Planning Application : - A/3/18/PL

Re. : - Arundel Acre / A27 Junction with Arundel Road , Angmering

Response to Technical Note for planning application A /3/18/ PL

Access Visibility Splays

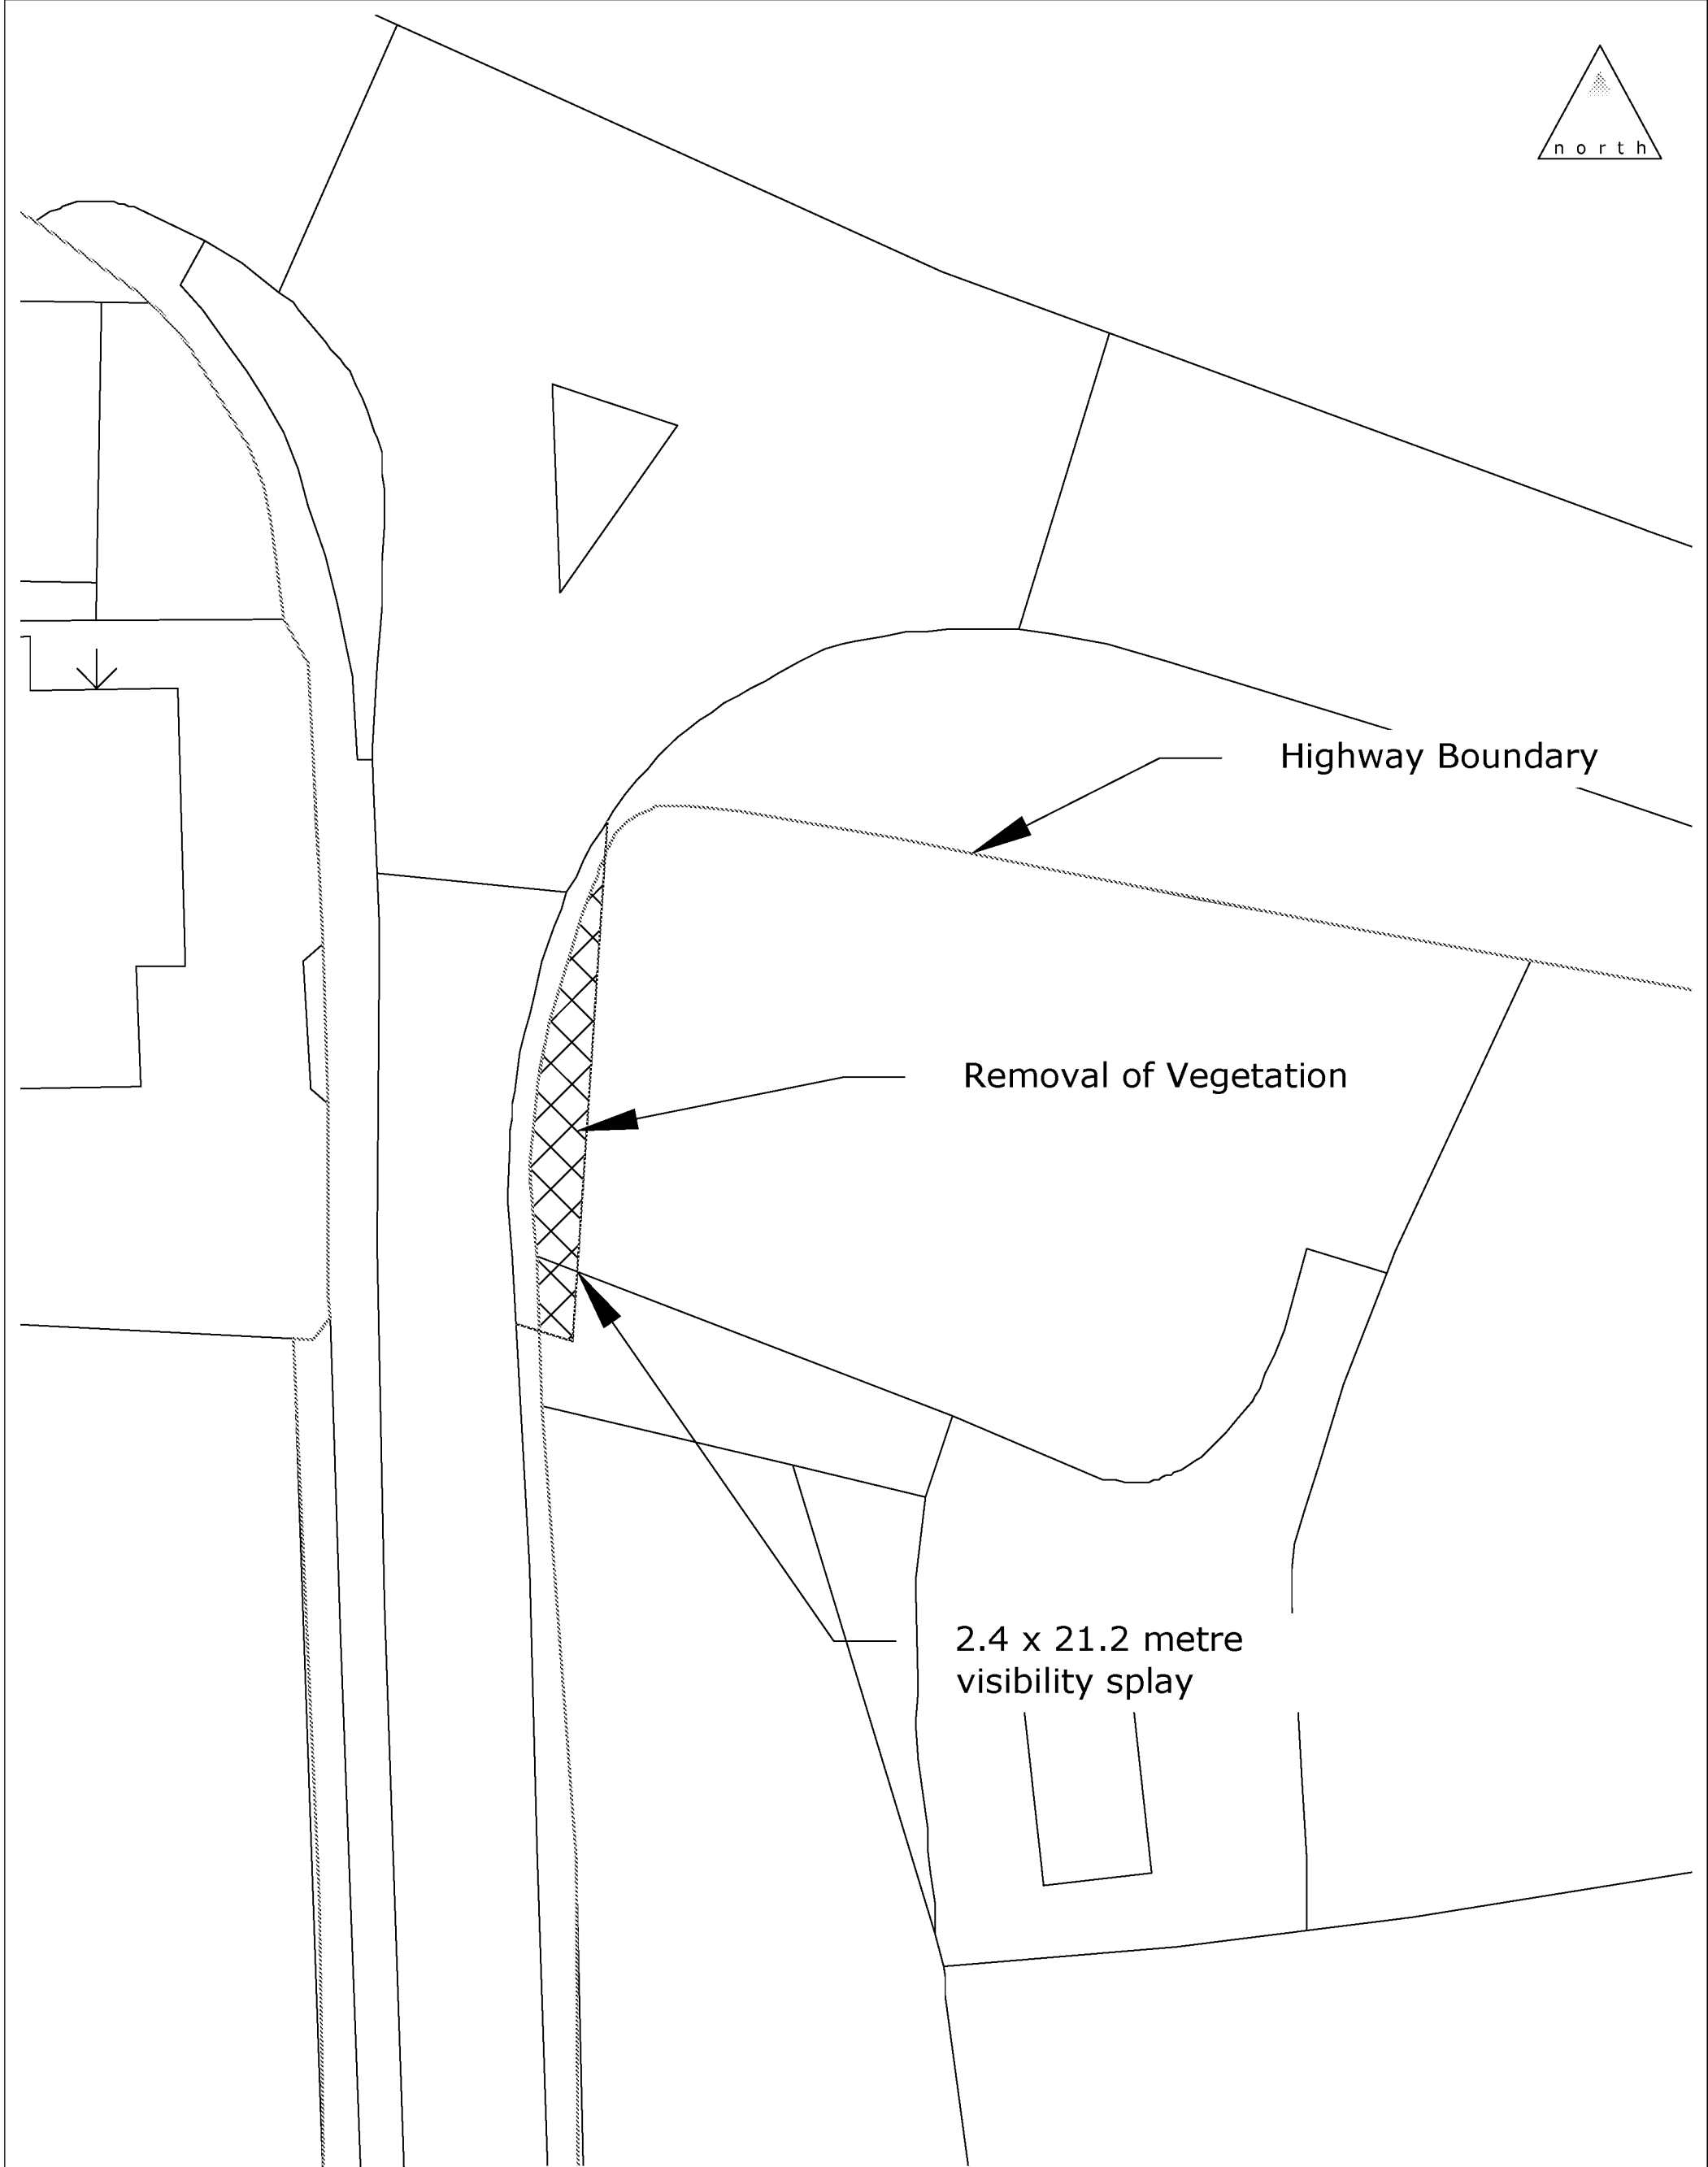
- 2.12 Our understanding from the highway search of the adopted highway the applicant cannot achieve visibility splays to the south without the requirement of third party land. The applicants consultant should demonstrate the land within the applicants control as part of the application.

- 3.2 Although the applicants consultant has gone some way to demonstrate reduced speeds and visibility splays further data is required over a longer period and taking into account the northern carriageway of Arundel Road.

Drawing:
1711056-SK01

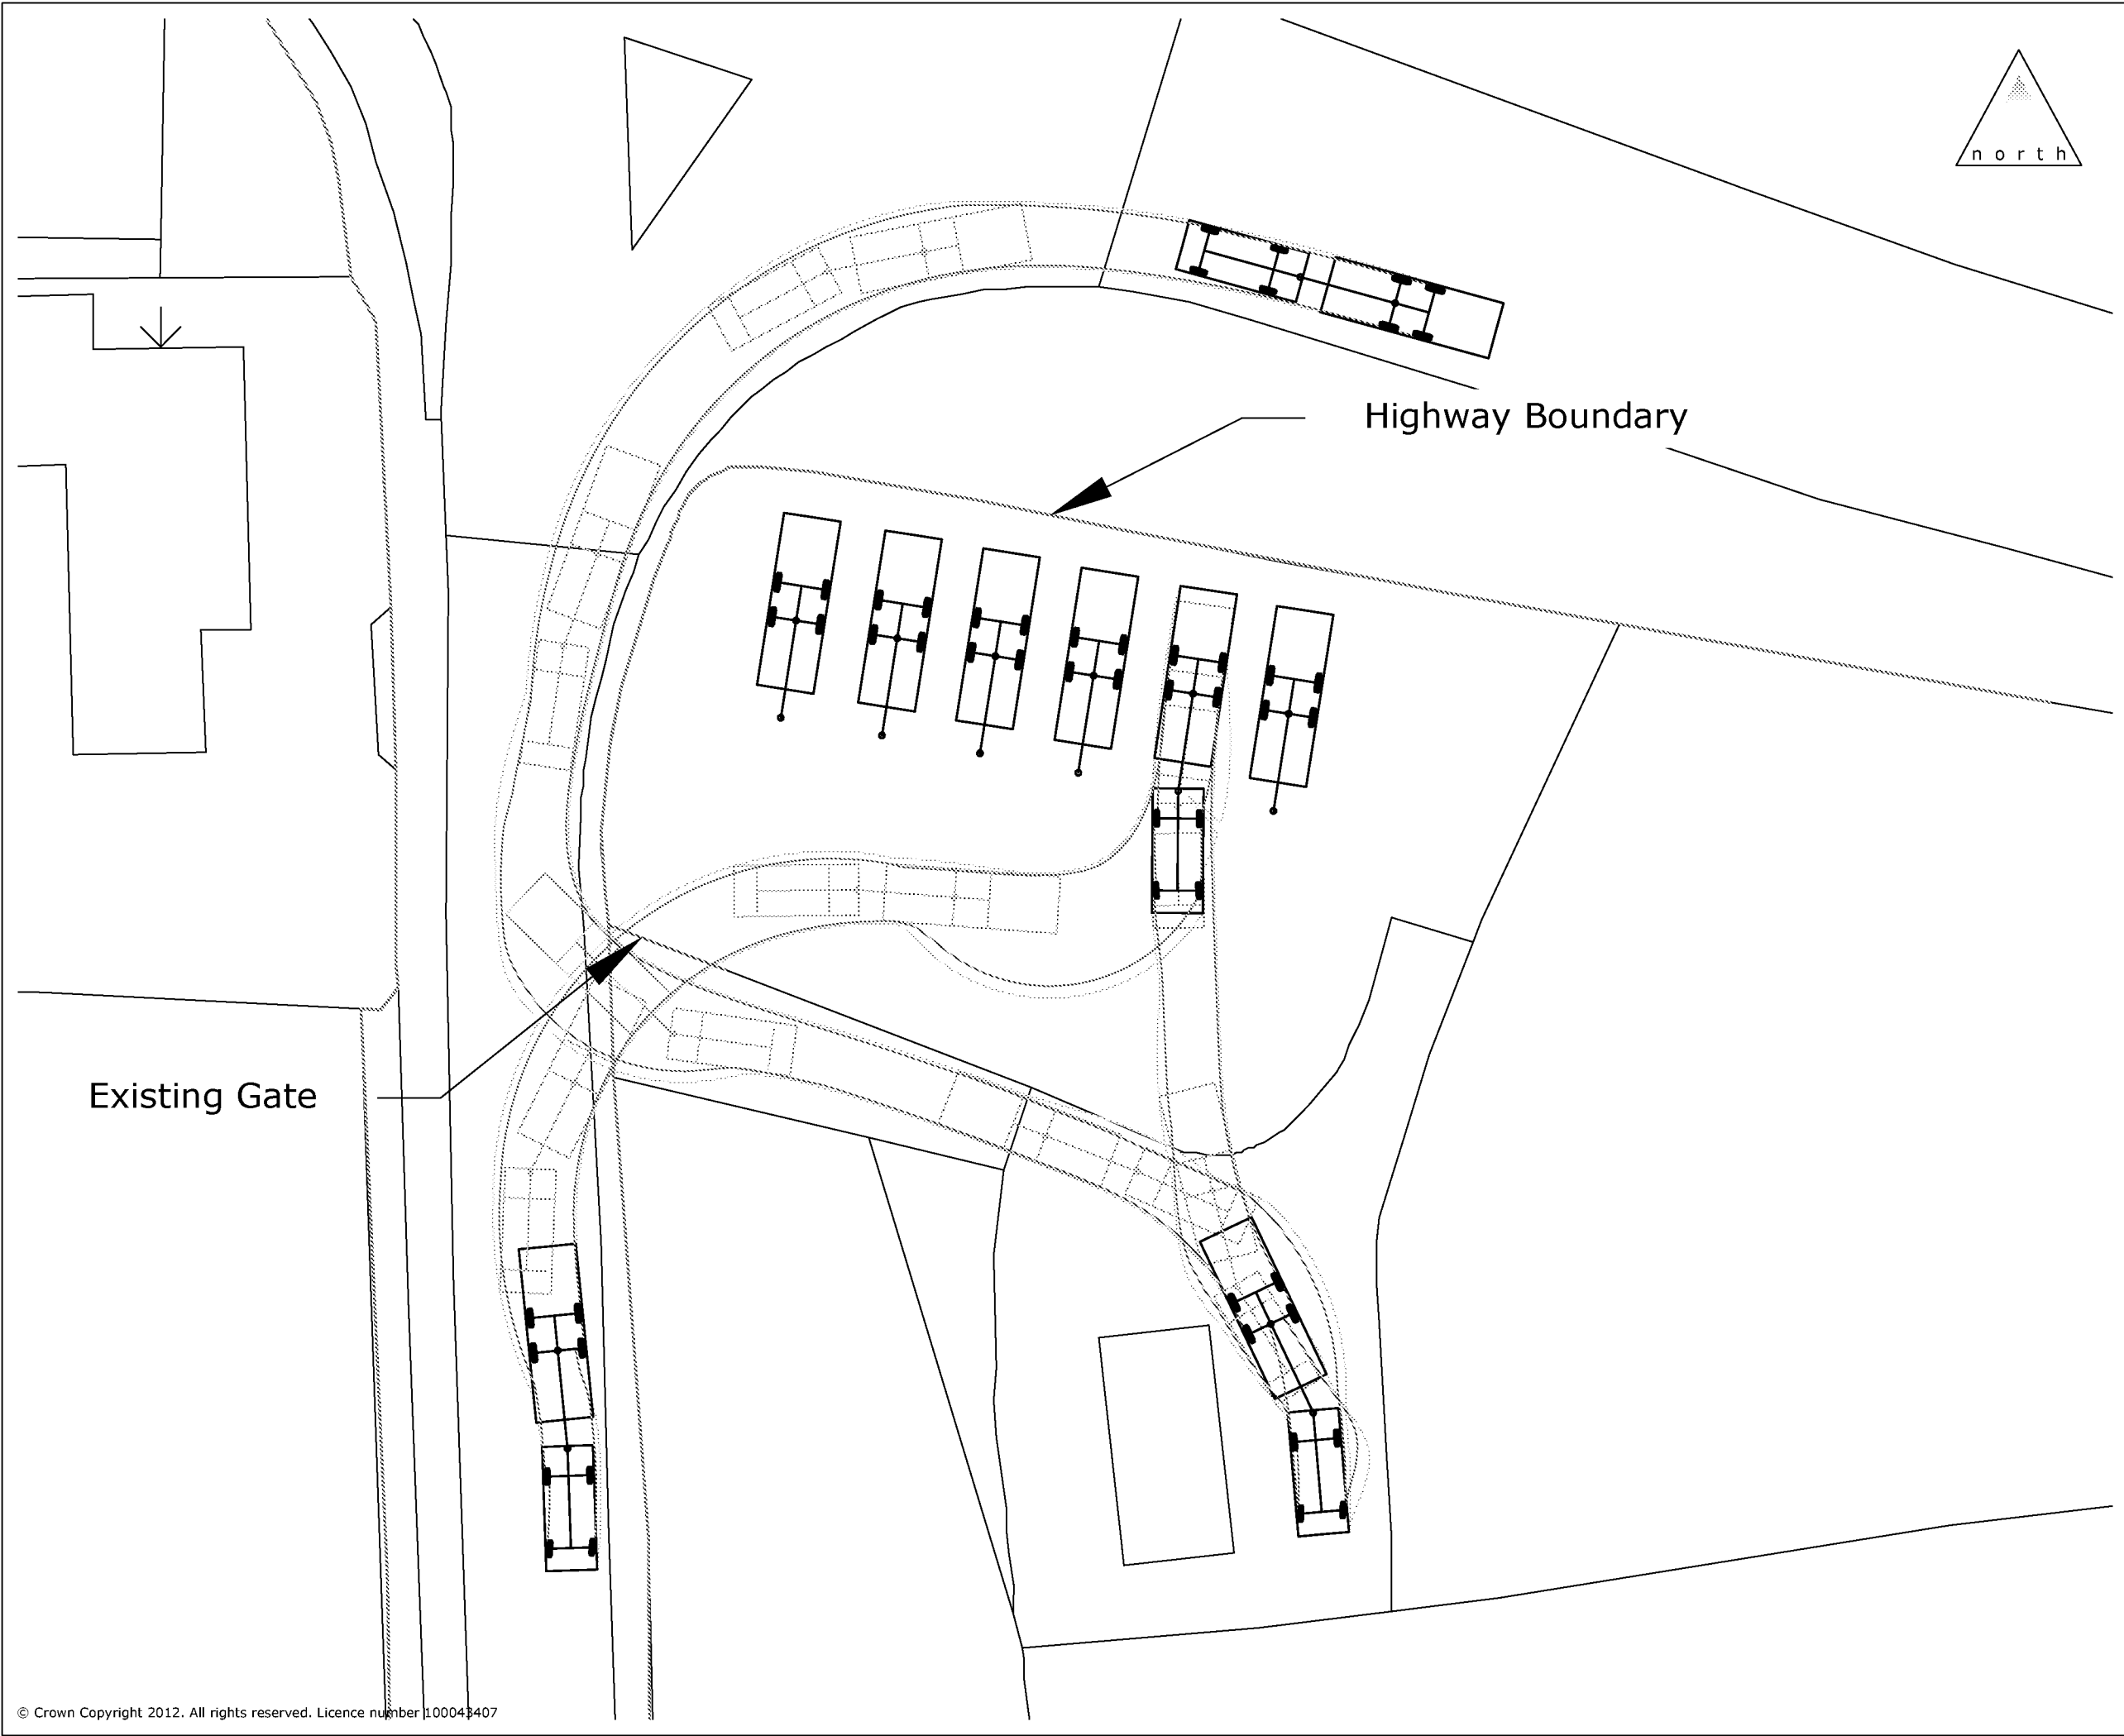
- 2.15. Vehicle tracking should be demonstrated using the correct size vehicles which will be entering and leaving site.
- 2.16 The tracking plan in appendix D does not take account of parked vehicles on the opposite side of the carriageway in Arundel Road, which will restrict the ability to carry out the manoeuvres as stated in appendix D.

The attached photographs taken recently shows how parked vehicles will obstruct the tracking path. The applicant will need to obtain a TRO for yellow lining along Arundel Road to achieve the turning paths ; the tracking appears to encroach in any event into the oncoming traffic when leaving the site.

The ability to leave the site with parked vehicles on the opposite side of the carriageway should require appendix D to be amended to take this into account.
